<b>Consultation Response from KC, Highways Development Management</b>
<b>2026/90725 land off Caledonian Road, Savile Town, Dewsbury, WF12 9NT</b>
<b>Erection of detached dwelling with barn conversion and associated works to form annex accommodation associated with new dwelling(Listed Building)</b>
<b>Date Responded: 8 May 2026</b>
<b>Responding Officer: Sheila Henley</b>
<b>Responding Ref: 15-1NW/15</b>

**Recommendation: No objection**

Plan ref: 3637 (0-) 01 B Proposed Site Plan; 3637 (0-) 04 Proposed Ground Floor Plan

Drawing Proposed Site Plan	Scale # A1 1:200
Drawing No. 3637 (0-) 01	Revision A

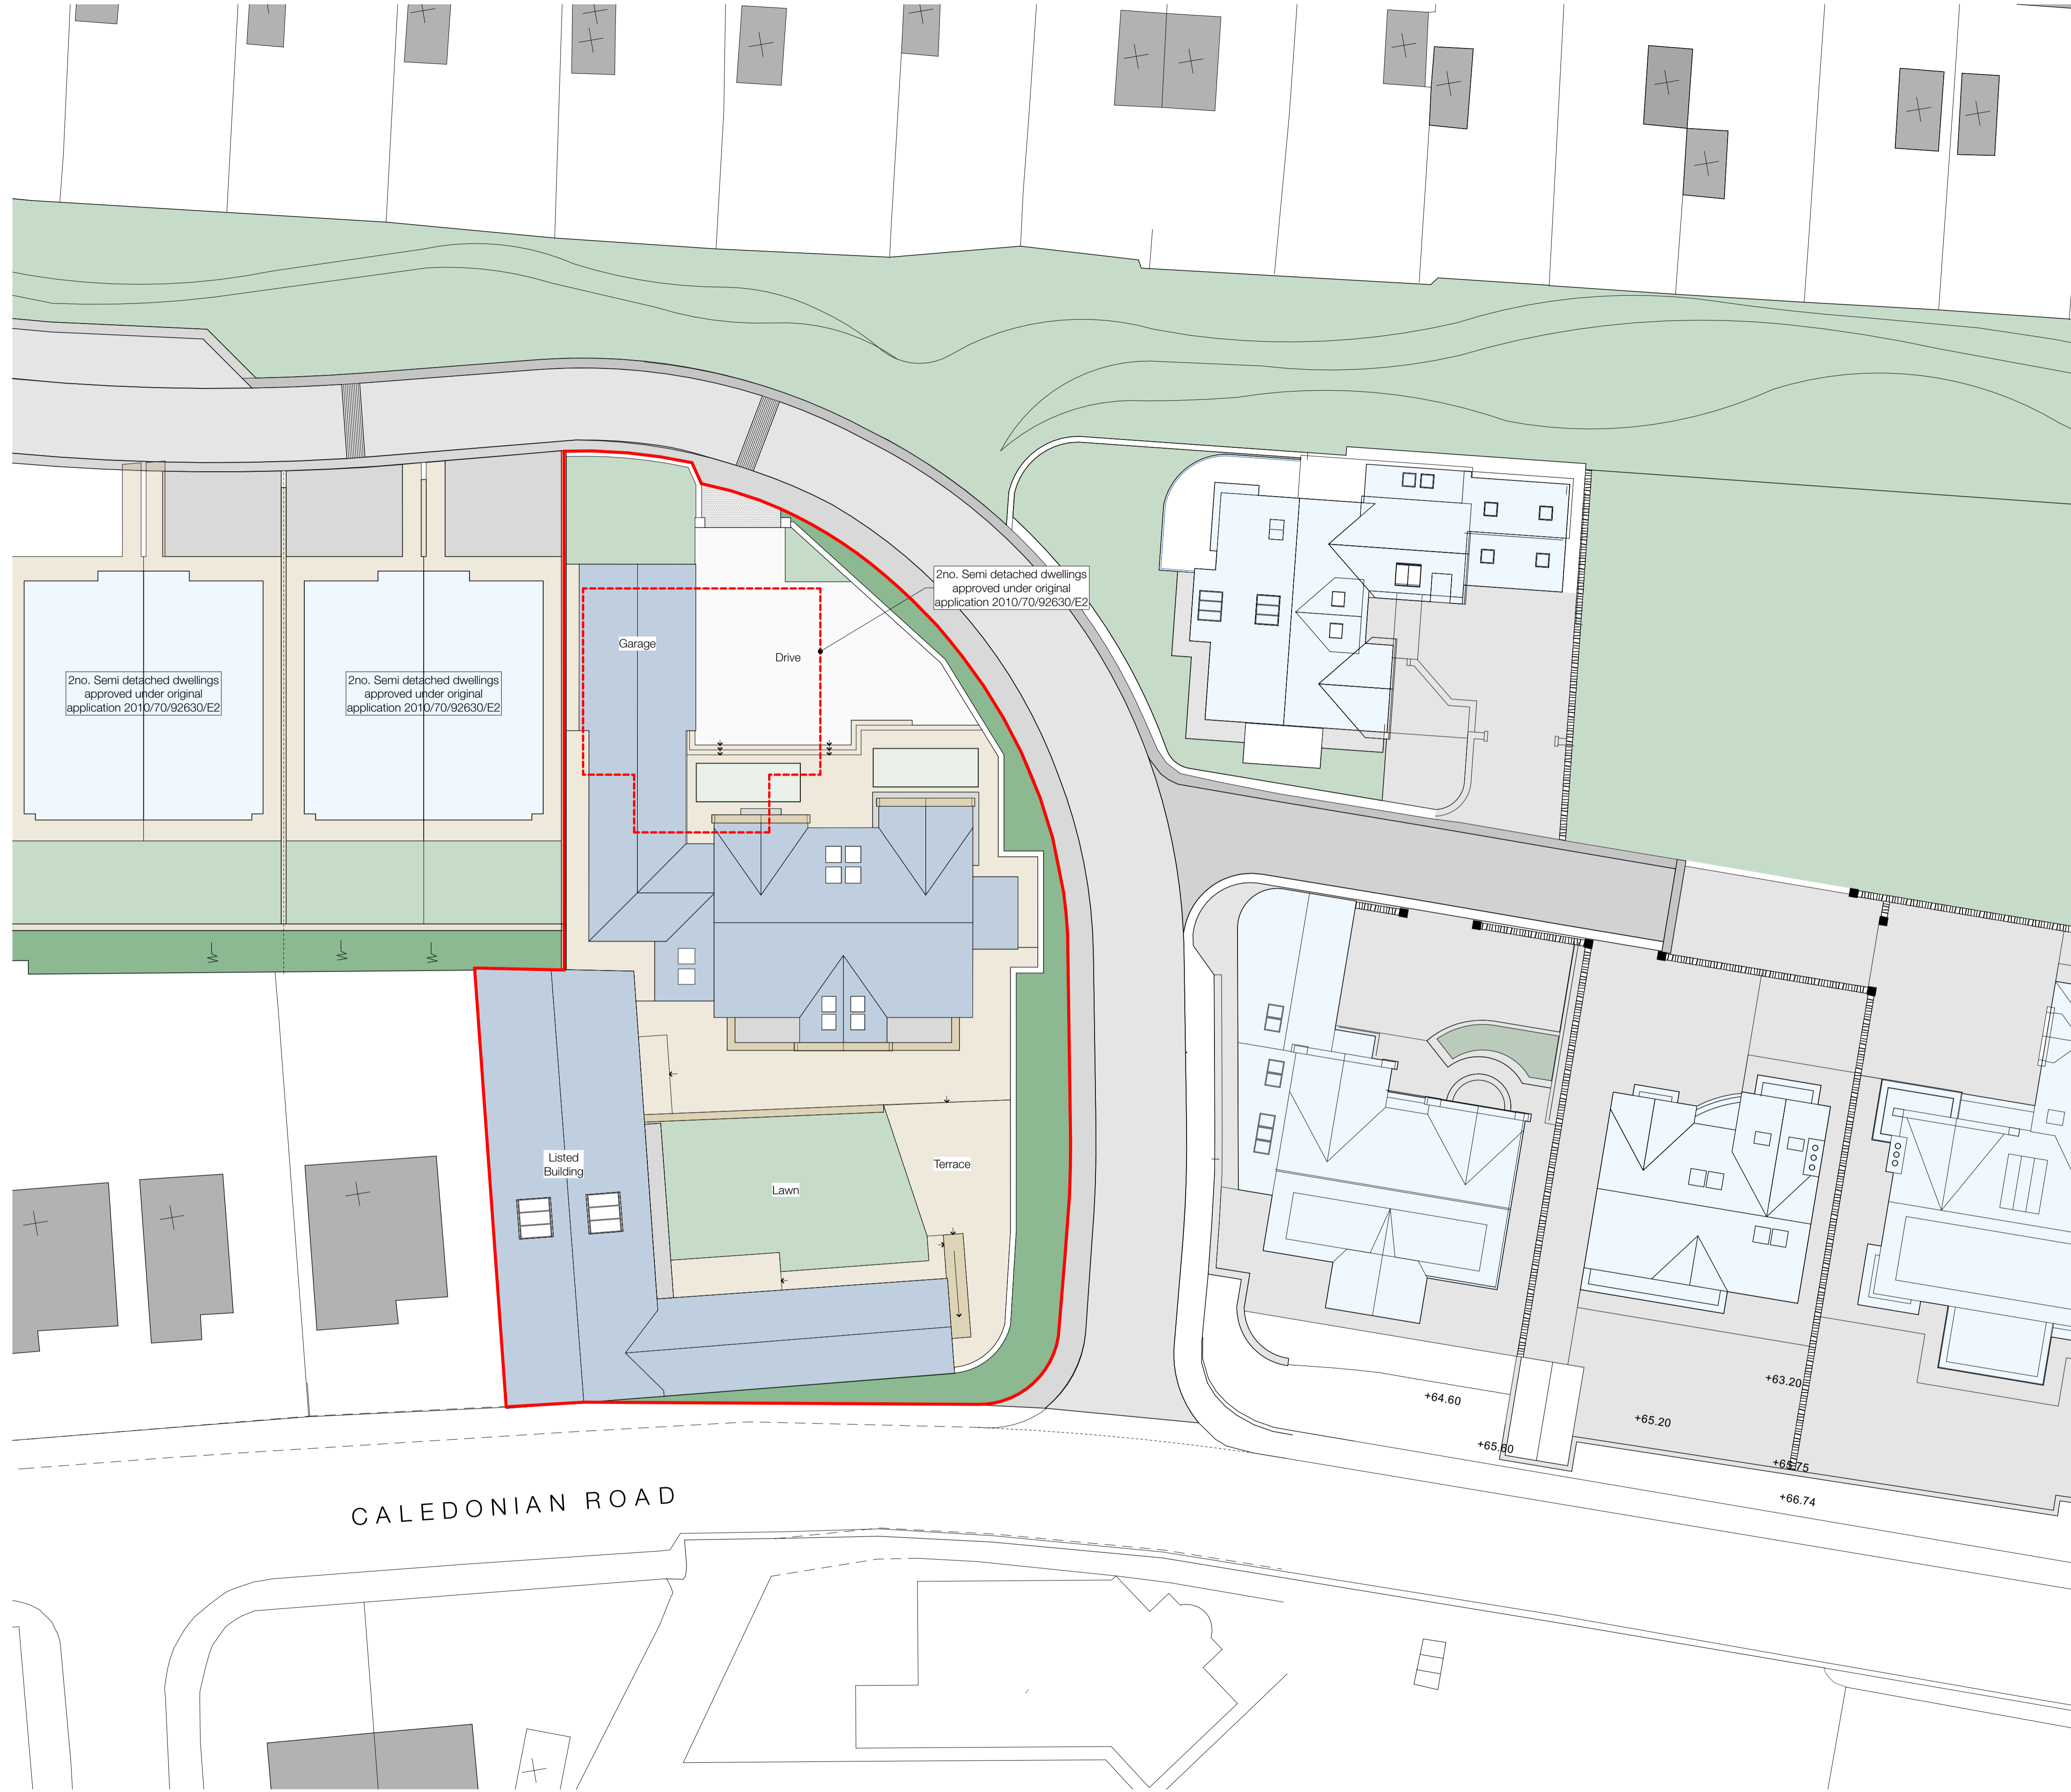
The proposed dwelling and annex include a gated plot access, triple garage, and areas of hardstanding for parking and turning plus bin collection point and electric vehicle charging point.

The proposed access is to be taken from the unadopted Meadow Avenue. A s38 Highway Agreement for road adoption is incomplete and, currently, Meadow Avenue is privately maintained.

The position of the intended access is like the easternmost semidetached dwelling approved under 2010/70/92630/E2 and sight lines should remain unobstructed.

The dimensions are all adequate with a c4.5m gated access suitable for shared vehicle and pedestrian use.

The triple garage would be suitable for three cars plus storage of cycles and other items to have a dimension of 6.1 x 9.2m exceeding the norm of 6 x 3m for each single element.

There is an ample hardstanding area in advance of the proposed garages and dwelling for parking and turning.

From the Planning Application form four on-plot car parking spaces are indicated to be provided which would meet exceed the advice from the KHDG SPD for four plus bedrooms unit and annex. There is space to park more on counting the garage allowing flexibility over car parking provision to accommodate visitors in keeping with policy LP22.

To support sustainable travel, there is to be an evcp installed and cycle parking could be included within the garages to meet the desire one space per unit from the Kirklees Highway Design Guide SPD.
